# **MEADOWBANK EDUCATION AND EMPLOYMENT PRECINCT SCHOOLS PROJECT**

## **RESPONSE TO SUBMISSIONS**

27 FEBRUARY 2020  
PREPARED FOR SCHOOL INFRASTRUCTURE NSW

GRASS SWALE/ DEPRESSION DETAIL PLAN AND SECTIONS

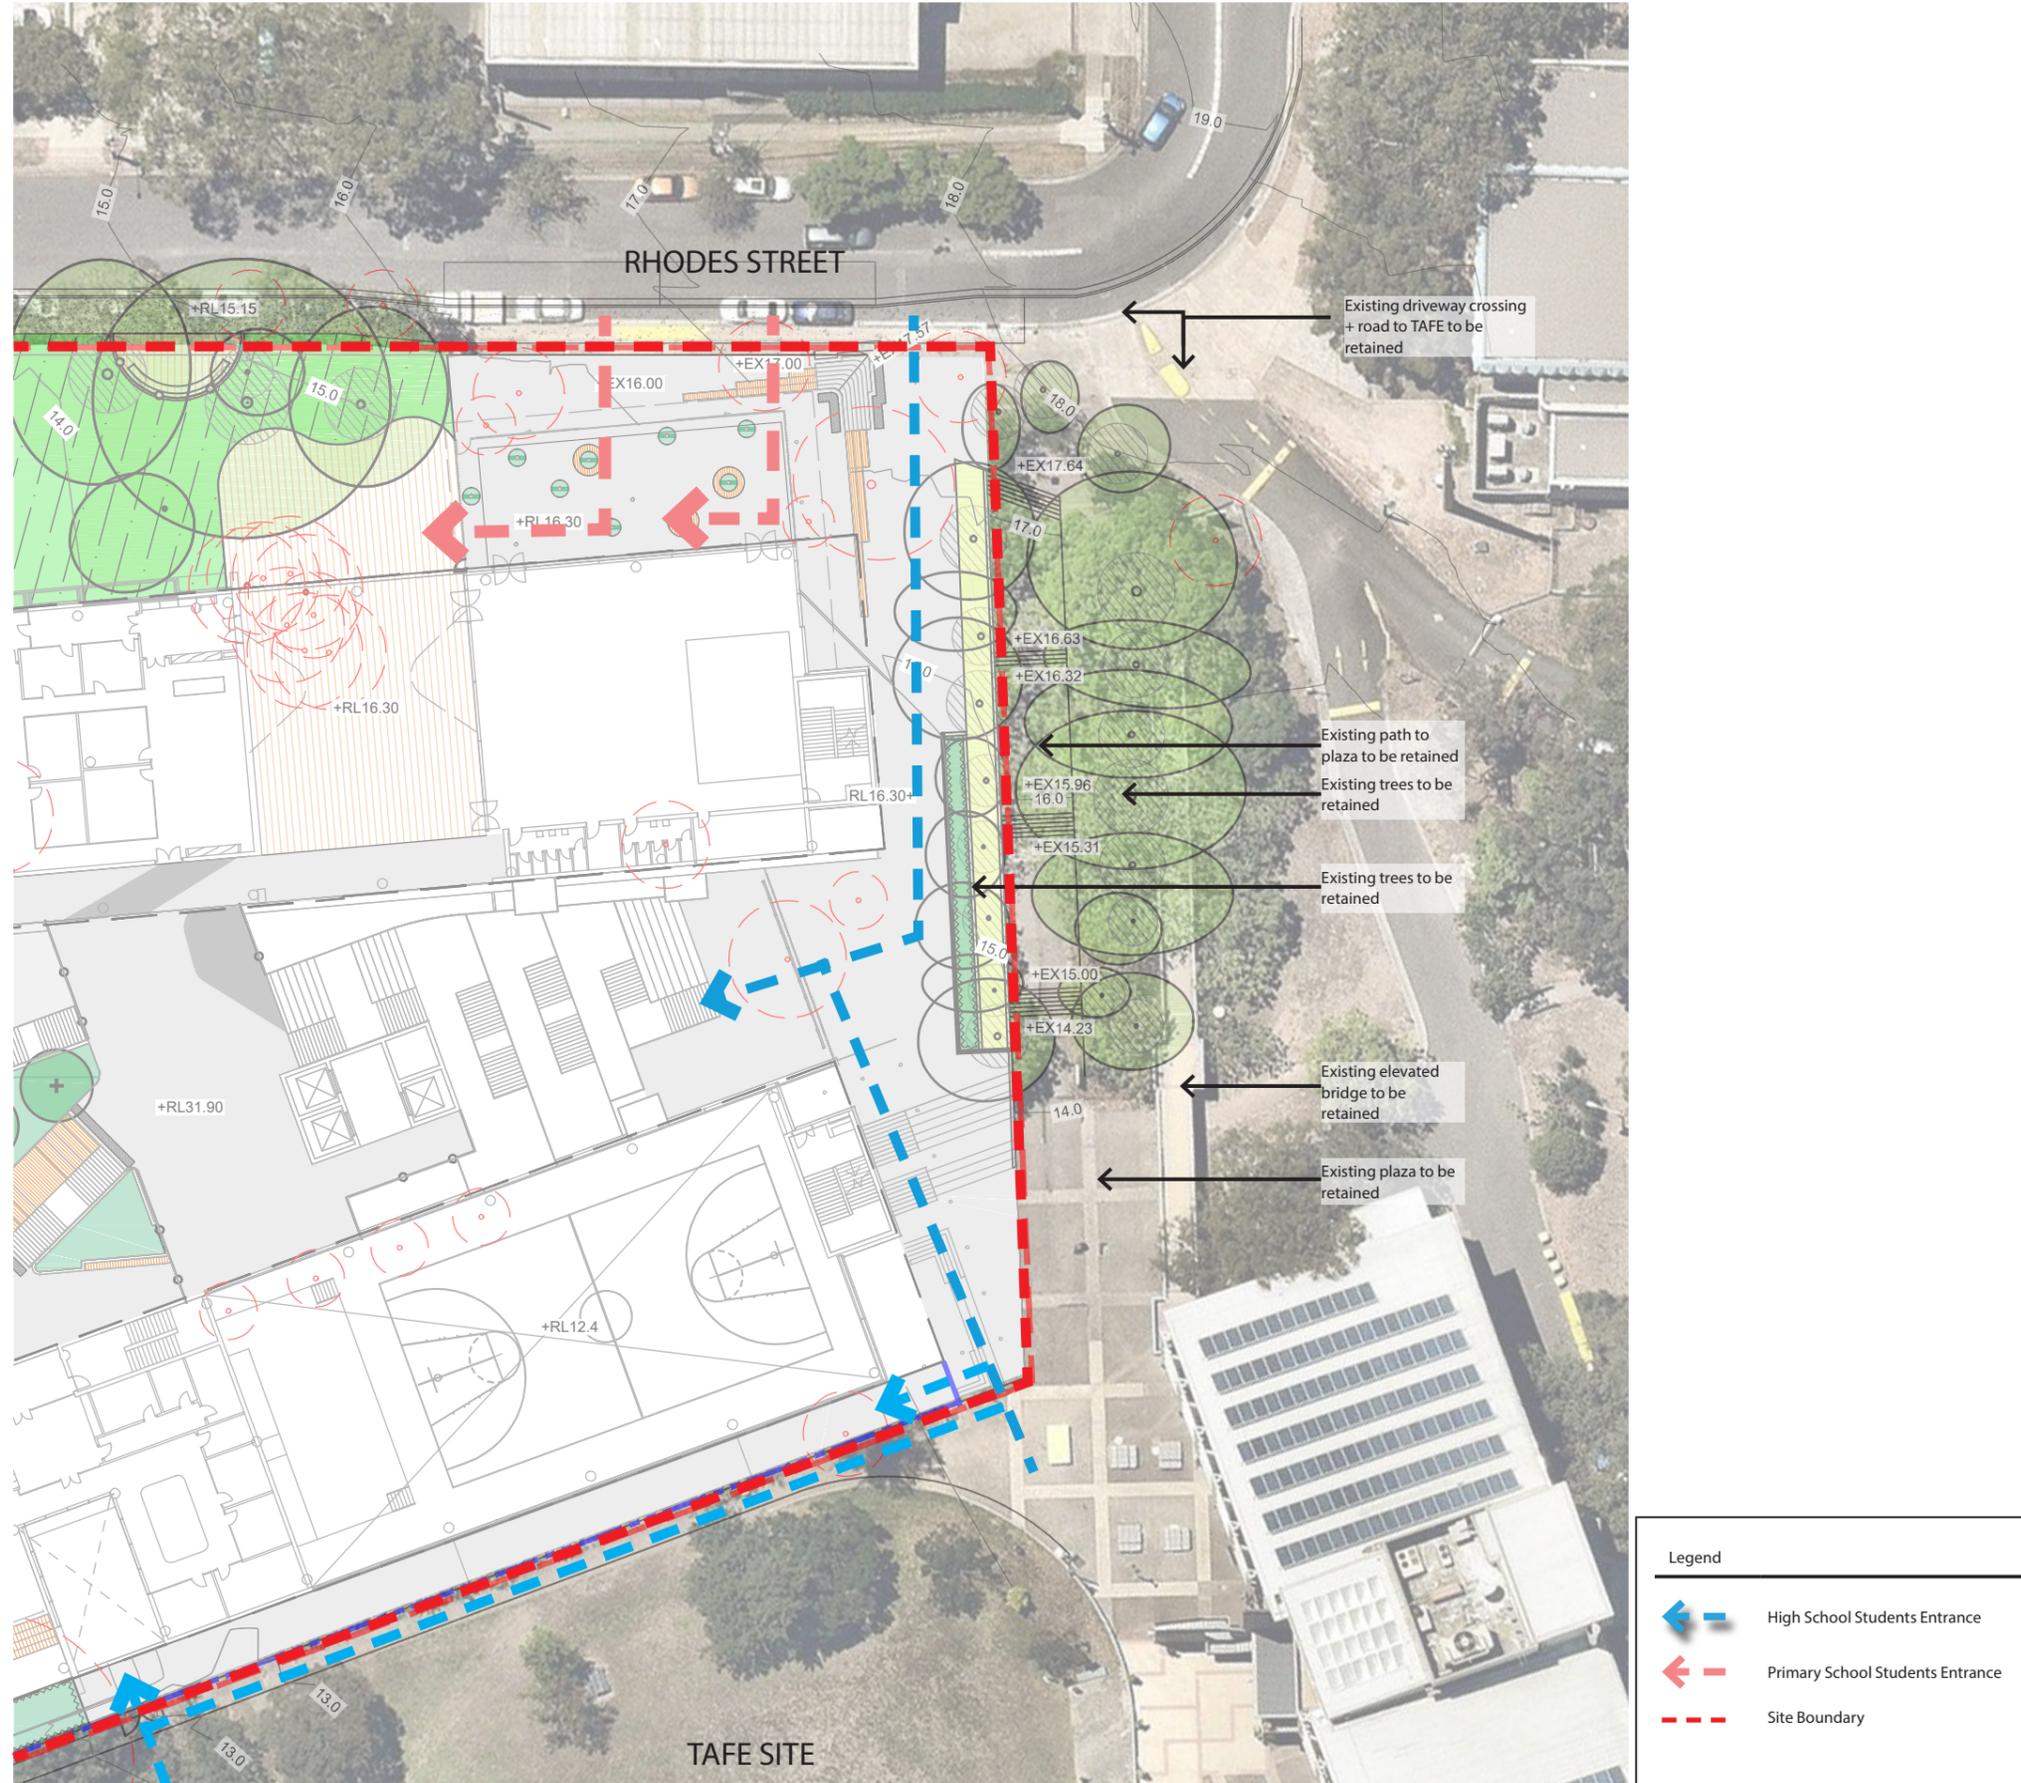
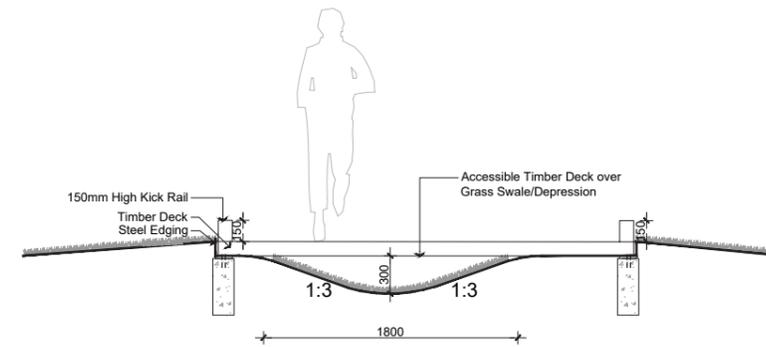
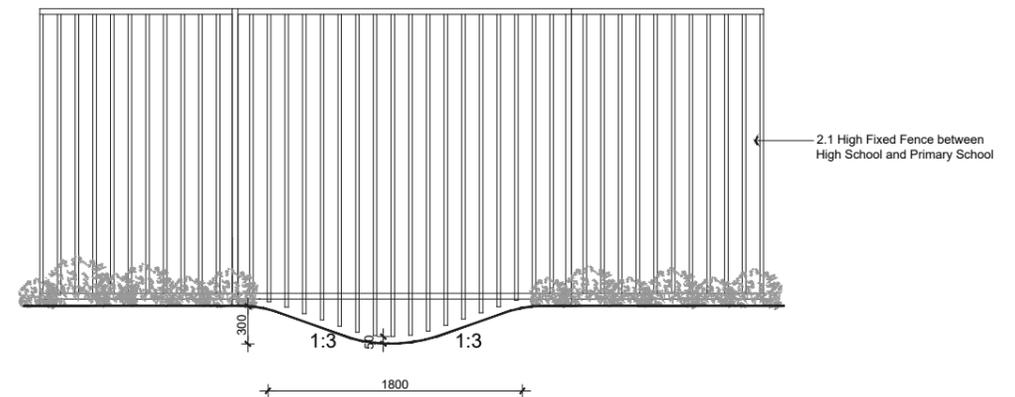
| Issue                                | Comment  | Response  | Refer to          |
|--------------------------------------|--|---|-------------------|
|                                      | <p>10. <i>Provide greater detail of the proposed swale that runs north/south through the site, including consideration of management and student safety.</i></p>           | <p>The swale is a shallow grass channel with gently sloping sides. It will be maintained the same as grass areas. Part of the swale is covered by a deck, providing a crossing location.</p>  | <p>Appendix B</p> |

CENTRAL TERRACE LANDSCAPE GRADING, MAINTENANCE AND PLANTING STRATEGY

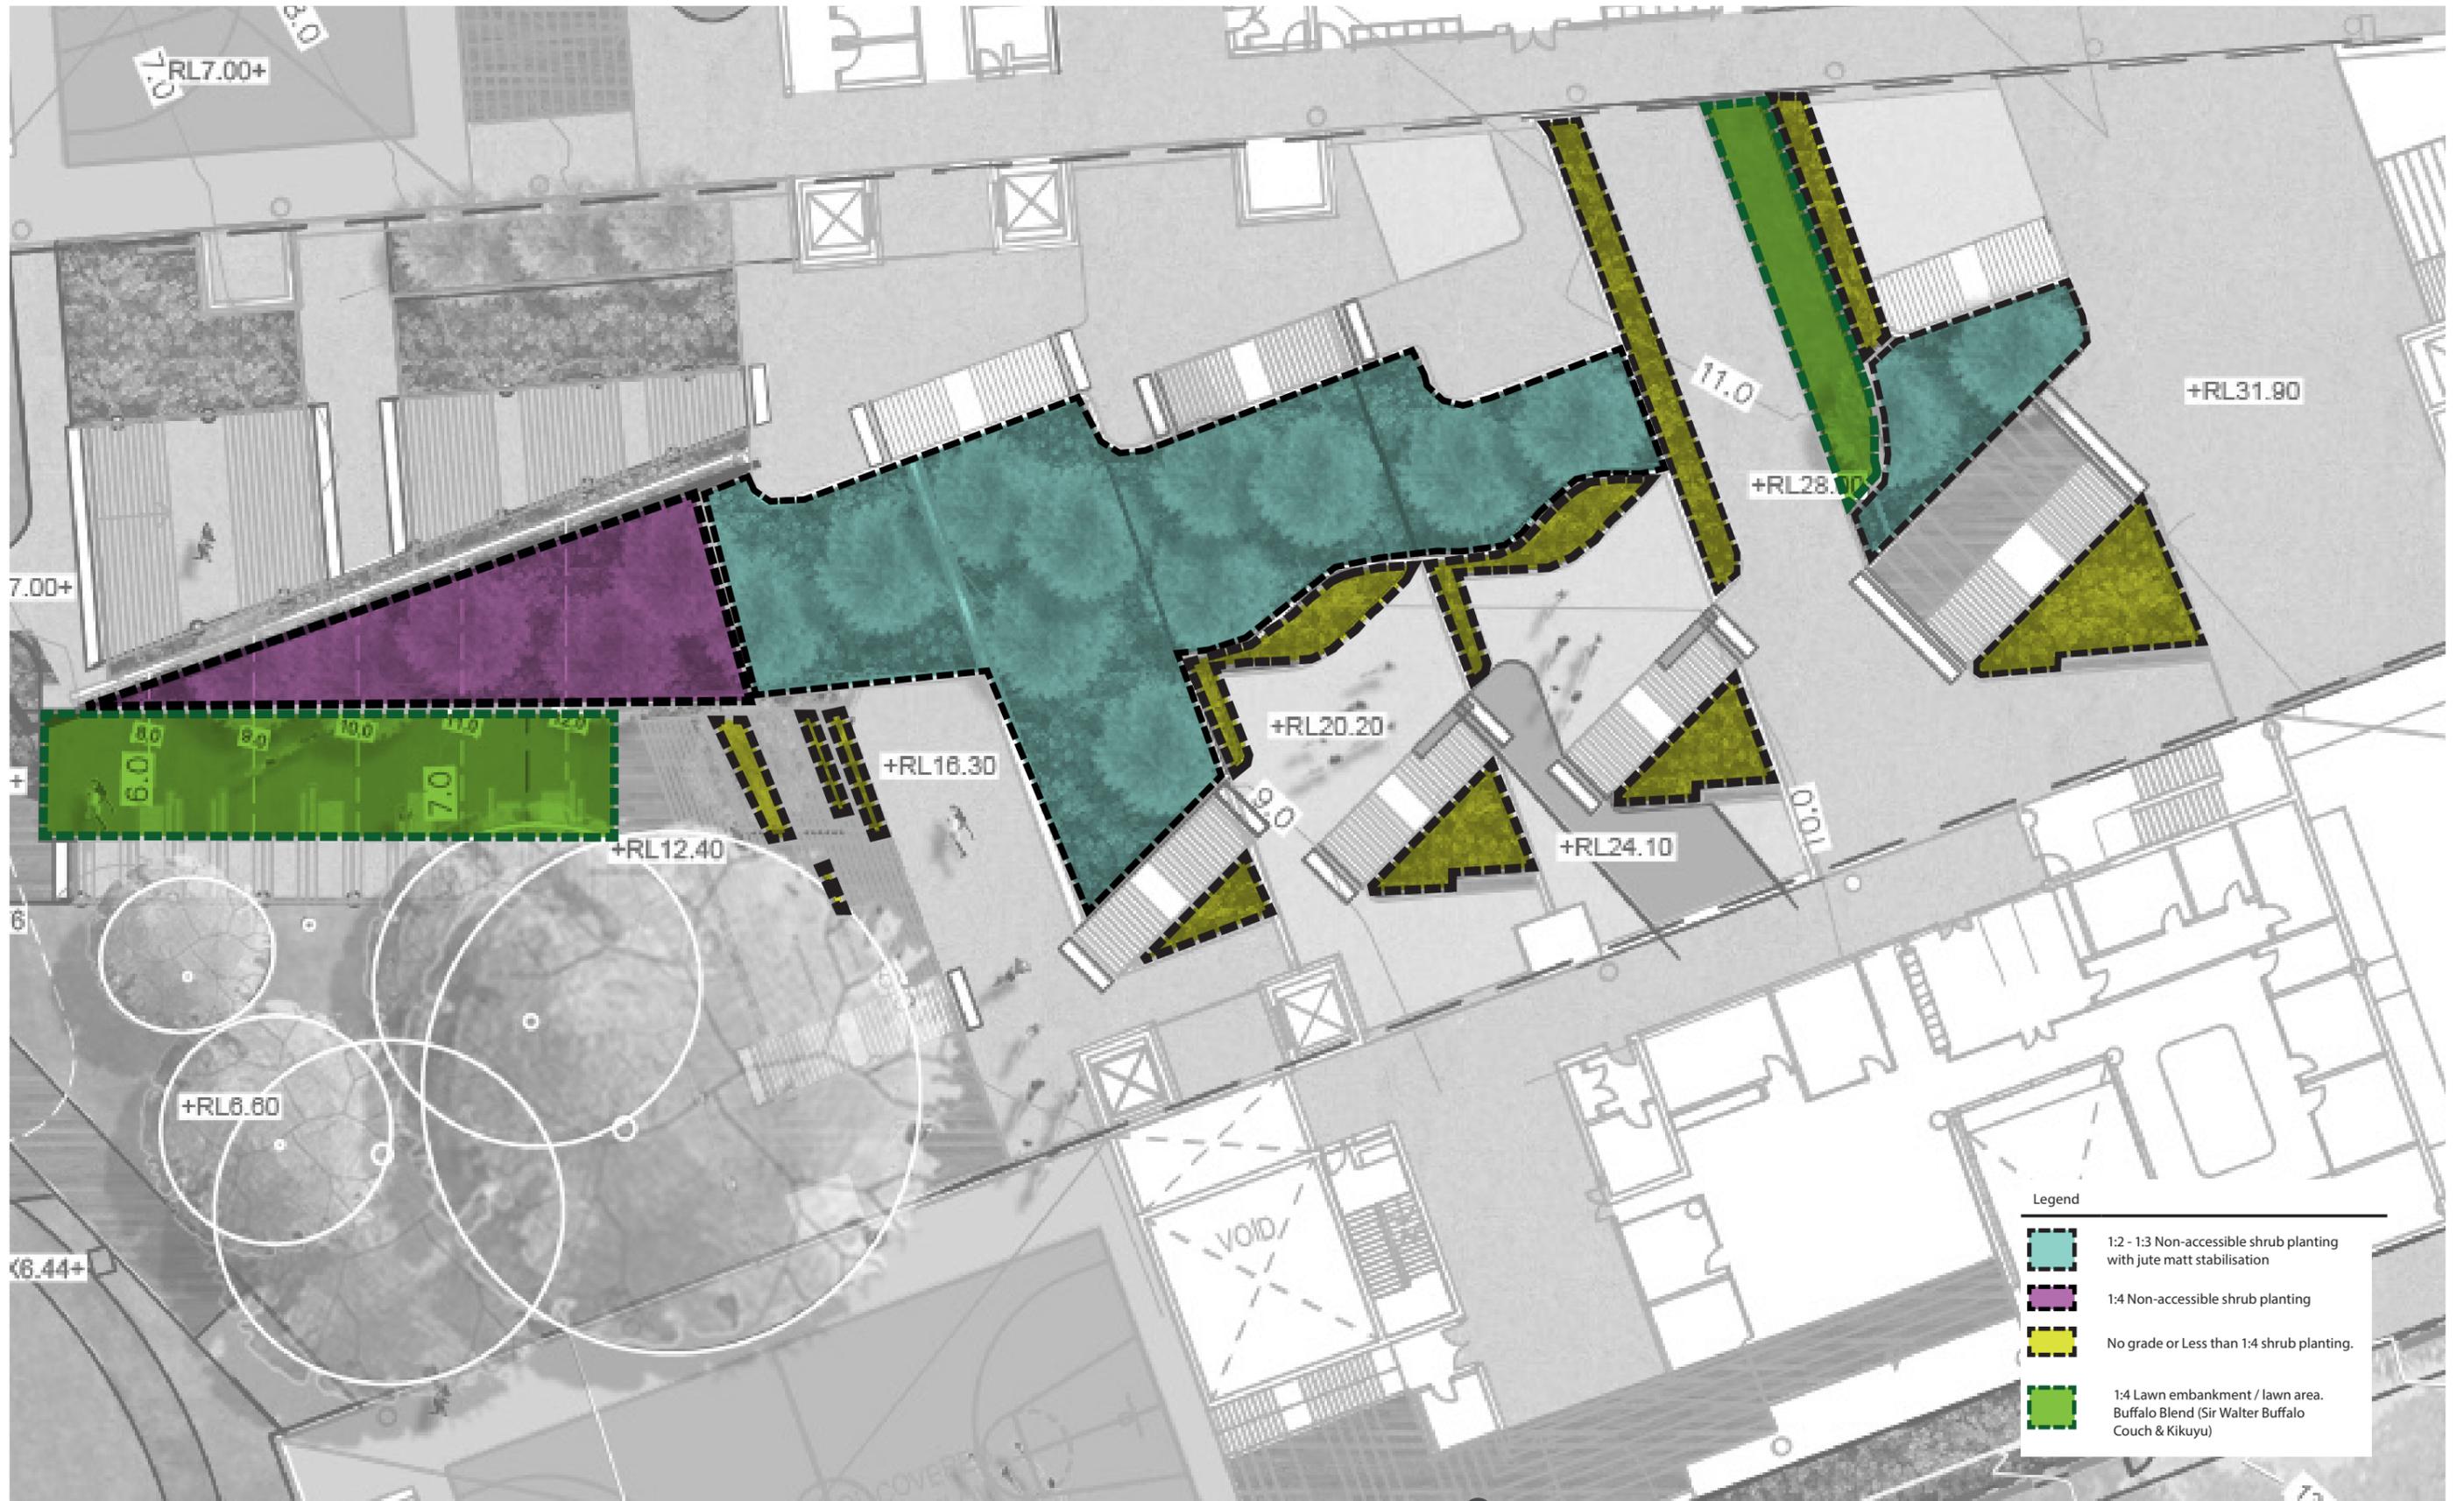
| Issue                    | Comment   | Response   | Refer to   |
|--------------------------|---|--|------------|
|                          | <p>9. <i>Provide an assessment of the viability of the proposed tree planting proposed above structure</i></p>  | <p>Additional details have been provided in the Updated Landscape Design Report and Plans.</p>   | Appendix B |

| Issue                                | Comment  | Response  | Refer to          |
|--------------------------------------|--|---|-------------------|
|                                      | <p><i>within the Central Landscape area. In addition, provide greater detail of the planter dimensions, soil depth and maintenance.</i></p>                                | <p>All proposed planting will conform with minimum soil depths and volumes in accordance with Council and the 'Apartment Design Guidelines':</p> <ul style="list-style-type: none"> <li>- Turf 200mm soil depth</li> <li>- Ground Cover 300-450mm soil depth</li> <li>- Shrubs 500-600mm soil depth</li> <li>- Small Trees (6-8m high) 800mm soil depth</li> <li>- Medium Trees (8-12m high) 1000mm soil depth</li> <li>- Large Trees (12-18m high) 1200-1500mm soil depth</li> </ul> <p>All volumes are subject to review against tree species, location, desired effect and current industry best practice standards. An arborist will provide specific advice about the volume of soil that planting required. A maintenance Specification will be provided.</p> |                   |
